**Consultation Response from KC,  
Highways Development Management****2024/92066 Land Adj, 264, Barnsley Road, Flockton, Wakefield, WF4 4AJ****Outline application for erection of dwelling****Date Responded: 28/08/2024.****Responding Officer: D. Stainsby****Responding Ref: K16-15/22**

Outline application for erection of dwelling at land adj, 264, Barnsley Road, Flockton, Wakefield, WF4 4AJ.

title site plan  
number 24065D-01-P01  
scale 1:200  
size A2

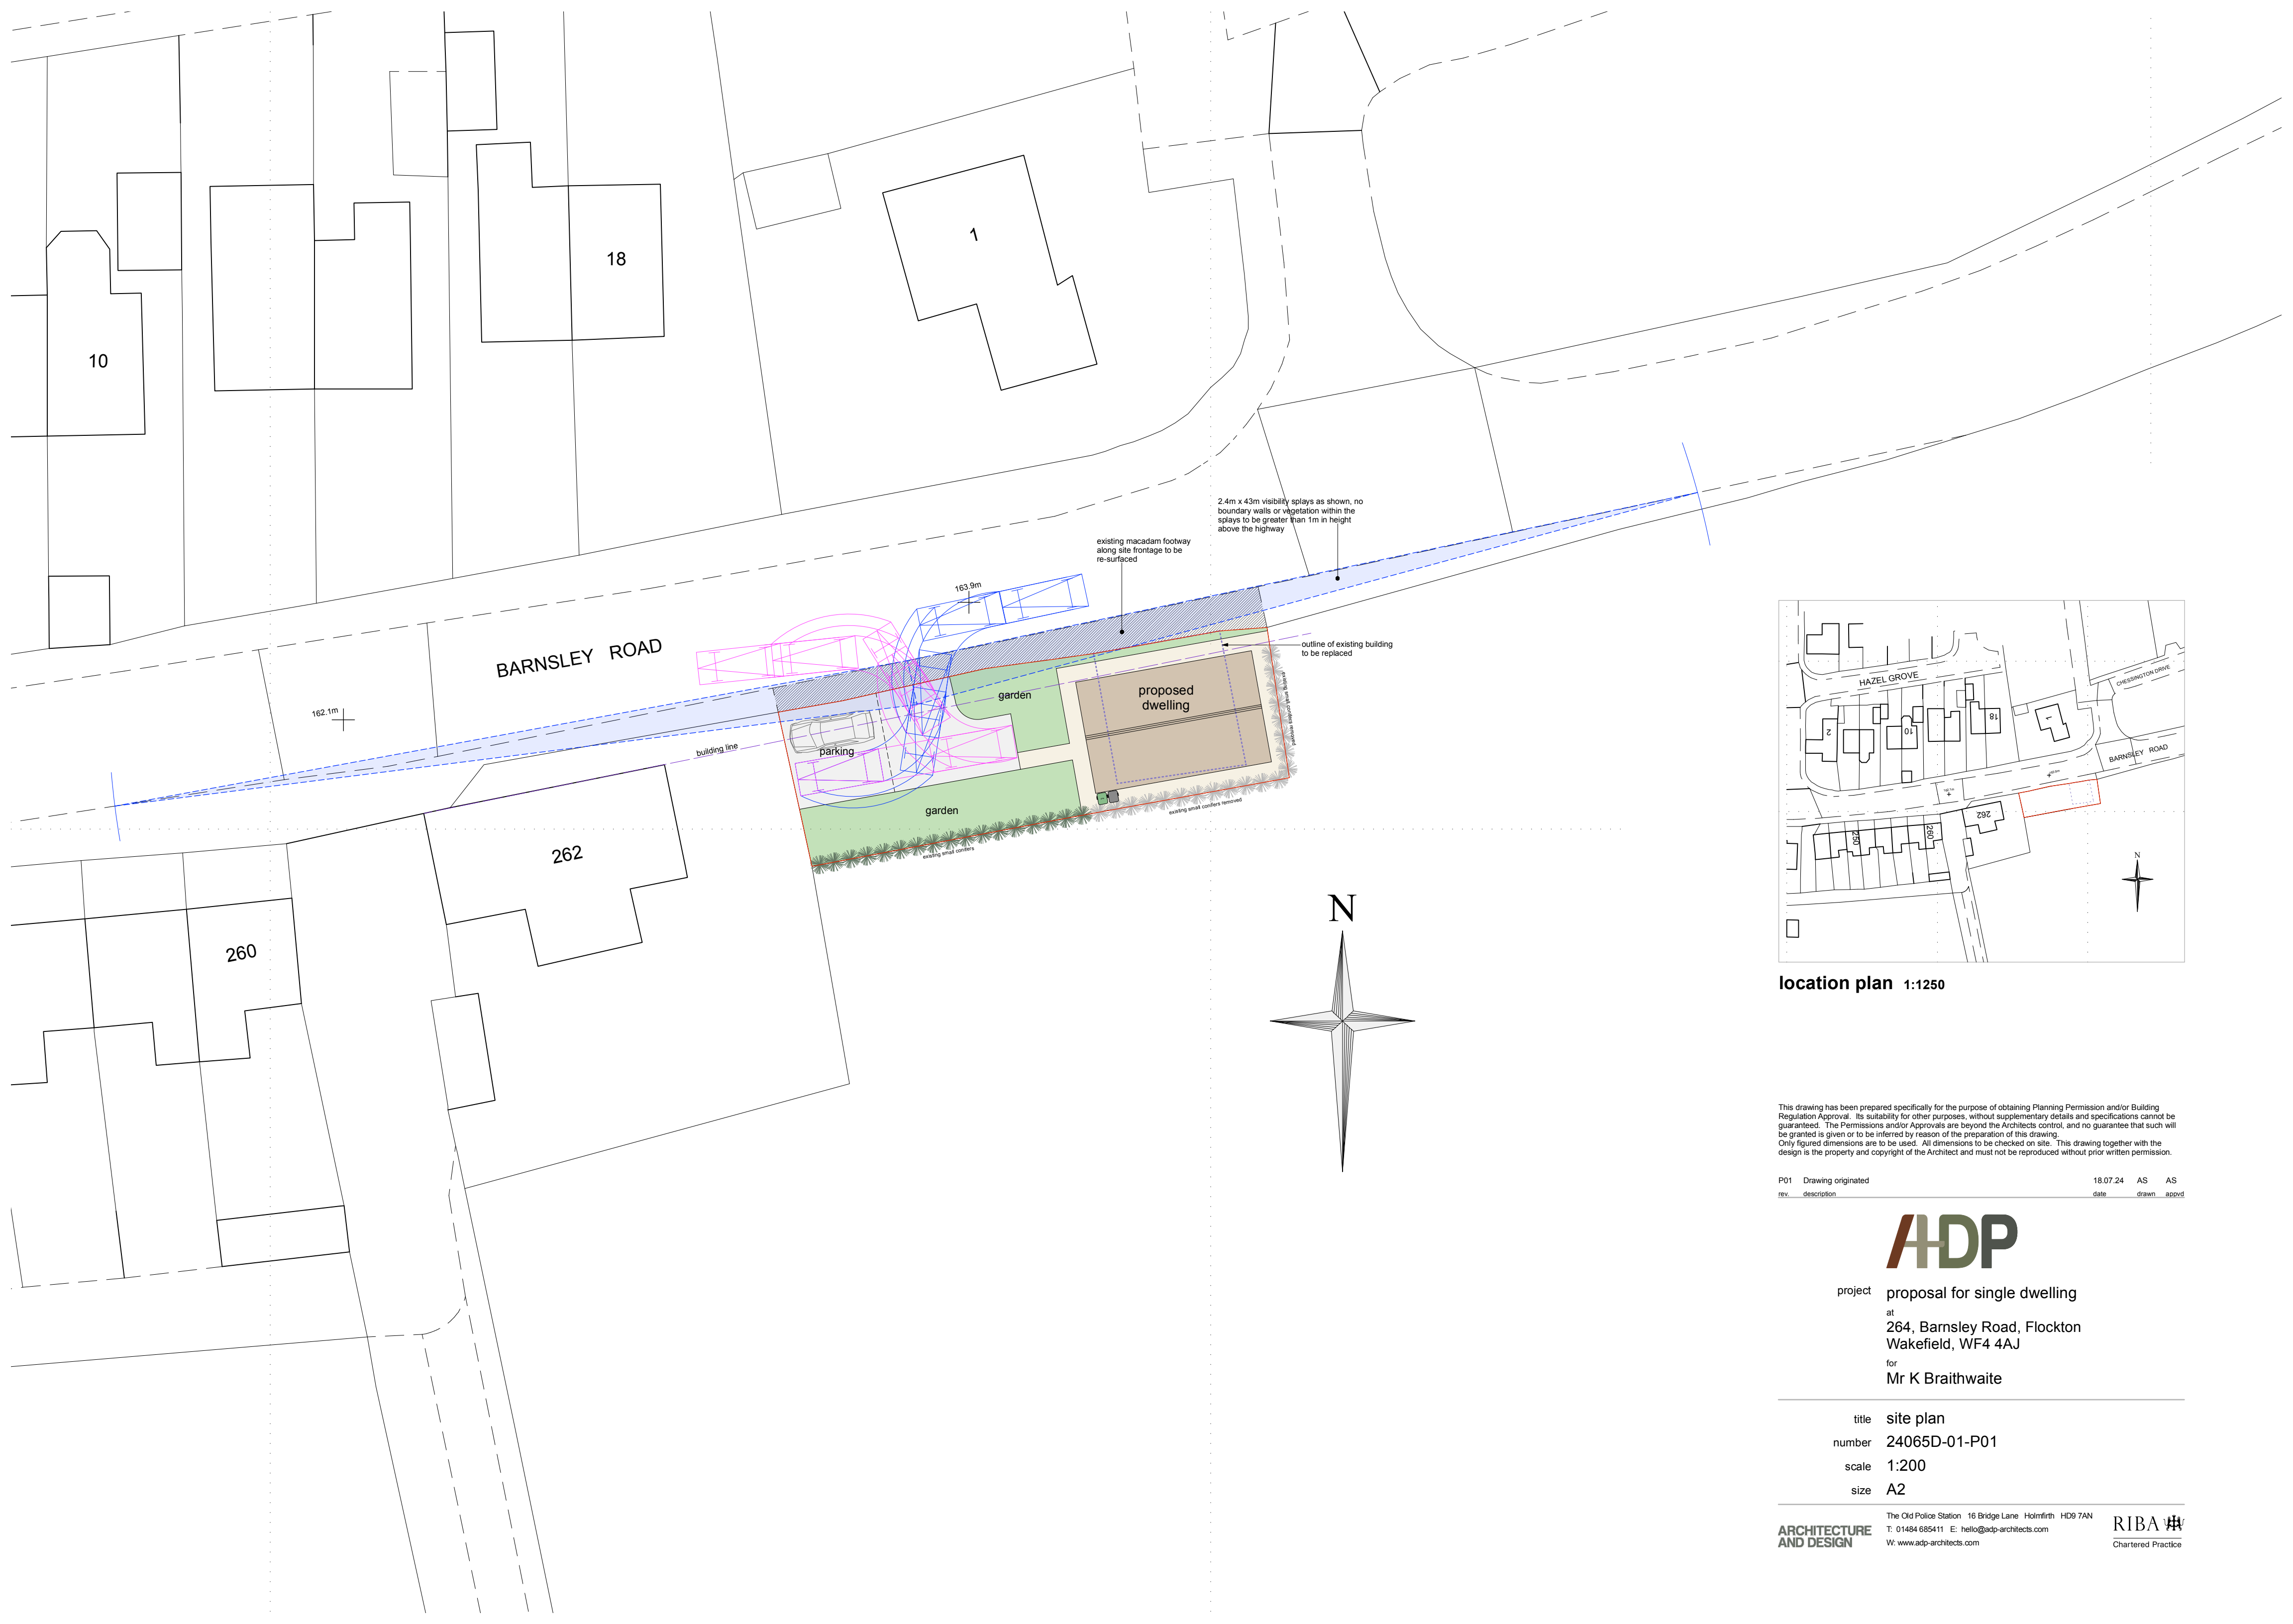
Two car parking spaces are proposed, together with internal turning which is acceptable for a three bedroomed house.

A new 4m wide access is proposed onto A637 Barnsley Road and the application has provided details that show visibility splays of 2.4 x 43m can be achieved at the proposed access, which is acceptable.

The applicant has stated that the existing macadam footway along the site frontage will be resurfaced. However, this is an adopted highway verge, and would require entering into a S184 agreement with the Highway Authority to carry out the necessary works

Visibility from the adjacent driveway to No 262 Barnsley Road should not be reduced by these proposals.

A bin storage area is shown on the plan. However, a bin collection/presentation point should be shown located adjacent to the public highway.

The bin collection/presentation point must not obstruct the adopted highway or the access road.
